## M25 junction 28 improvement scheme

TR010029

### 9.98 Applicant's comments on the London Borough of Havering's Deadline 6 submissions

May 2021

PROPOSED CROSS-SECTION OF A12 EASTBOUND OFF-SLIP ROAD AT CHAINAGE 707
SECTION D-D
Scale 1:250

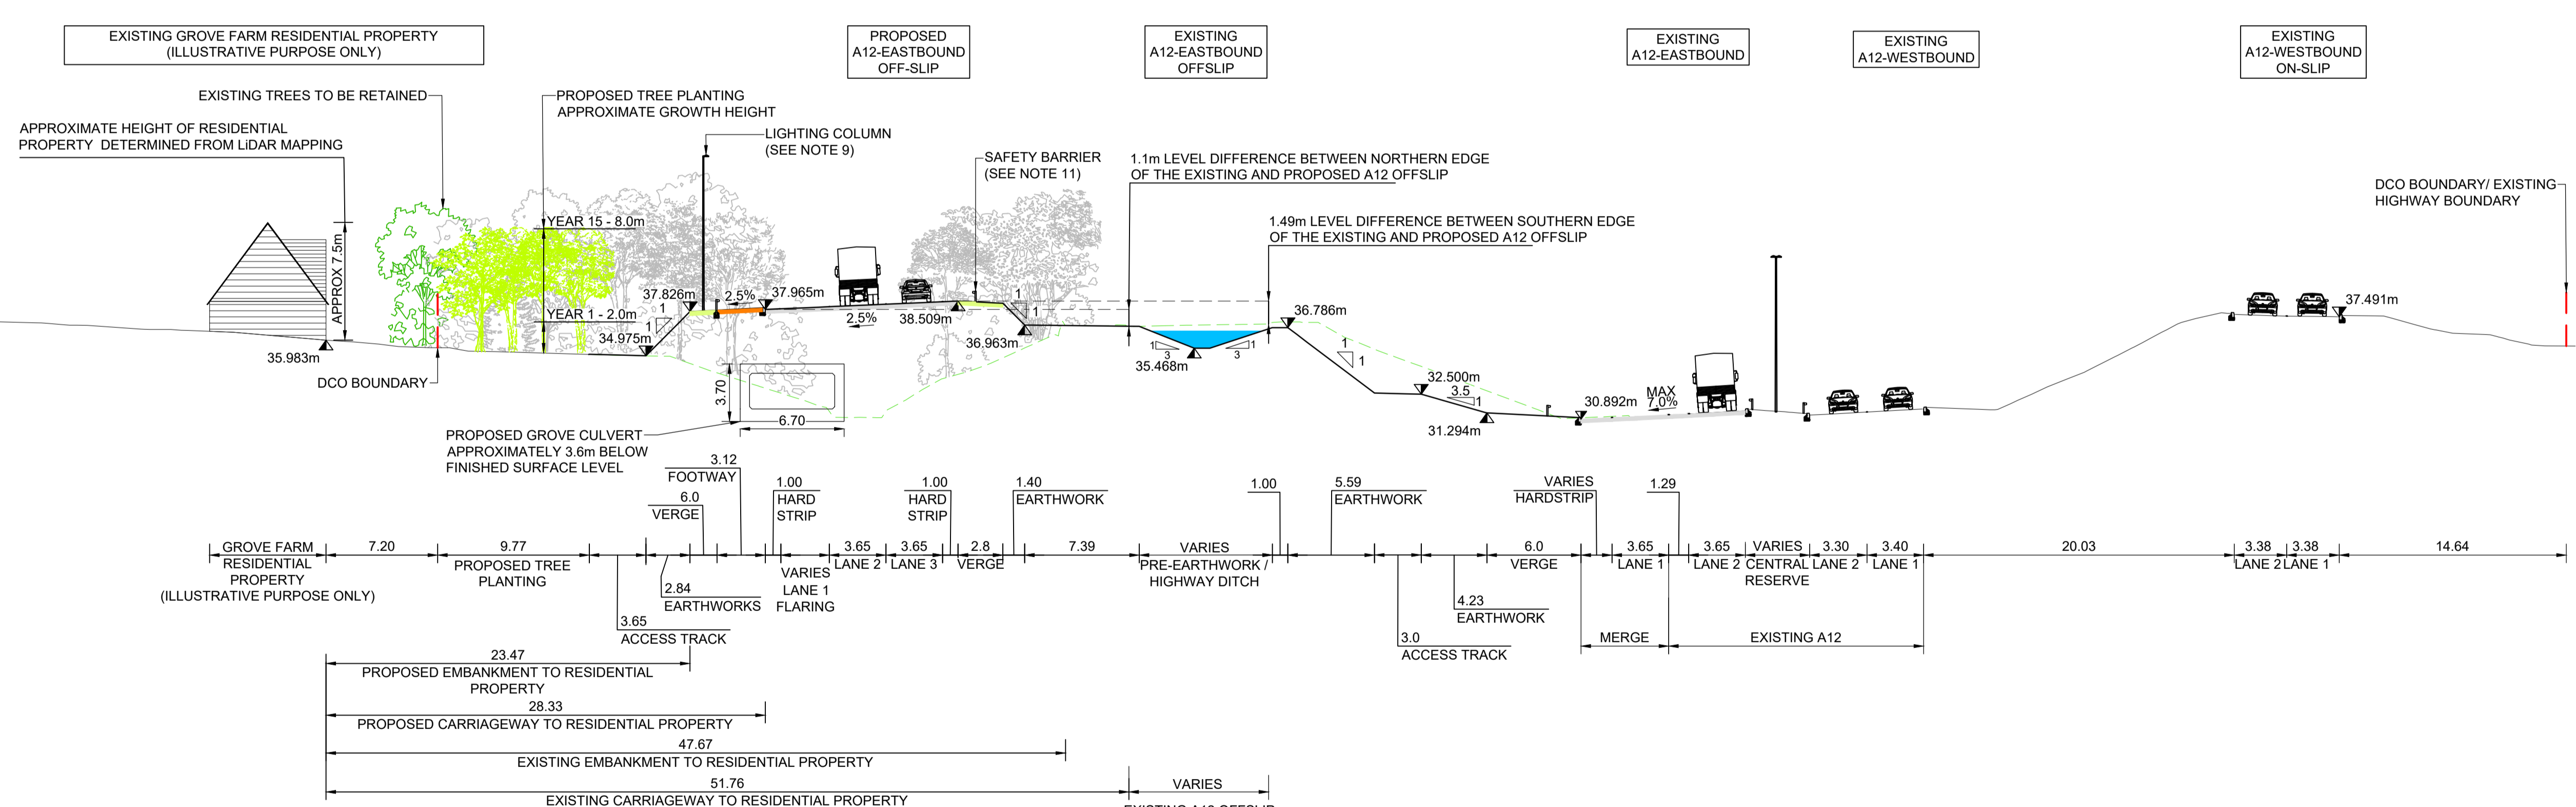
Response reference:	Question	HE Response
		Changes in noise smaller than 1dB are negligible, and the results at Grove Farm can be seen to be smaller than 1dB in Tables 6.1 and 6.2 of Appendix 6.3 (REP5-024).
REP6-036-05	LB Havering recommends a permanent acoustic barrier 2m above the final carriageway height along the A12 eastbound off-slip road around to the Grove Farm entrance. The barrier can be painted green and planted on the Grove Farm side to soften the view and provide additional vegetative cover.	<p>Highways England has estimated the performance of a 2m noise barrier along the A12 eastbound off-slip around to the Grove Farm entrance, as noted during ISH3. A 2m high noise barrier in this position would change the overall noise levels at Grove Farm by less than half a decibel as noted in paragraph 4.1.13 in Highways England written summary of ISH3 (TR010029/EXAM/9.96). The noise levels at Grove Farm are dominated by the traffic on the M25 carriageway, which would not be screened by a barrier in this location. The overall impact of the Scheme would remain negligible if a noise barrier were to be constructed in this location.</p> <p>Given that there would be no change in noise impacts from a noise barrier in this location Highways England disagree with London Borough of Havering's recommendation.</p>

REP6-036-06	The benefits of the barrier will be to provide physical separation between motor vehicles and Grove Farm, provide visual interruption between source and receiver, which can reduce psychological awareness of a source, reduce maximum noise levels from short term transient events and subject to the vegetation planting filter vehicle exhaust air pollutants.	<p>A visual screening fence is proposed to be provided for Grove Farm instead of a noise barrier and this will be added to the next iteration of the REAC. The visual screen is explicitly secured under requirement 5(3)(g) of the DCO submitted at Deadline 7 (TR010029/APP/3.1(6)).</p> <p>Physical separation and visual interruption would be provided by the proposed visual screen. The visual screening of traffic by the fence is also likely to help reduce psychological awareness, and the reduced awareness may lead to perceptions of improved noise conditions, even if there were no change in noise levels.</p>
